25 September 2024

Carolina Construction of Fayetteville
3117 Cope Street
Fayetteville, North Carolina 28306

Reference: Footing Evaluation
4955 Ray Road
Spring Lake, North Carolina

INTEGRAL SLAB FOOTING  
DETAIL AT BEARING WALL

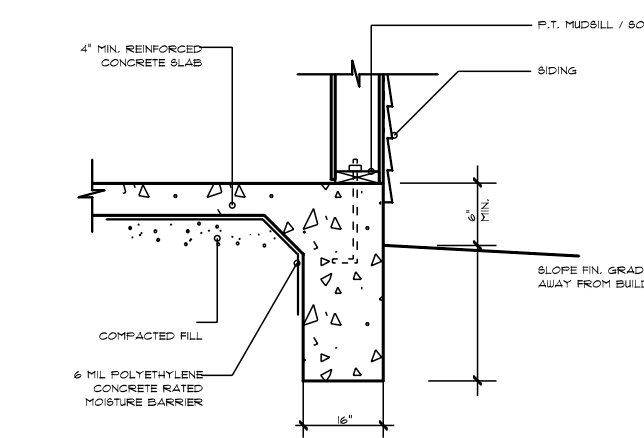
OTG Consulting, PLLC (OTG) was requested to evaluate the previously placed footing for the residence at the above referenced property. OTG understands that during the layout and placement of the foundation, concrete projection was not achieved along an approximately 5 foot long stretch of footing. With the stem wall construction, concerns were raised on the eccentric loading to the footing.

For repair, OTG recommends that the stretch of footing with limited projection be excavated an additional 12 inches wide and 8 inches thick in front of the footing. No 4 reinforcing steel should be doweled and epoxied into the existing footing at 12 inches on center, a minimum of 4 inches into the footing, extend out 4 inches into the new footing, and placed at the mid-height of the footing.

Based on review of the onsite repairs, the work performed meets the recommendation and will support the proposed loads from the residence.
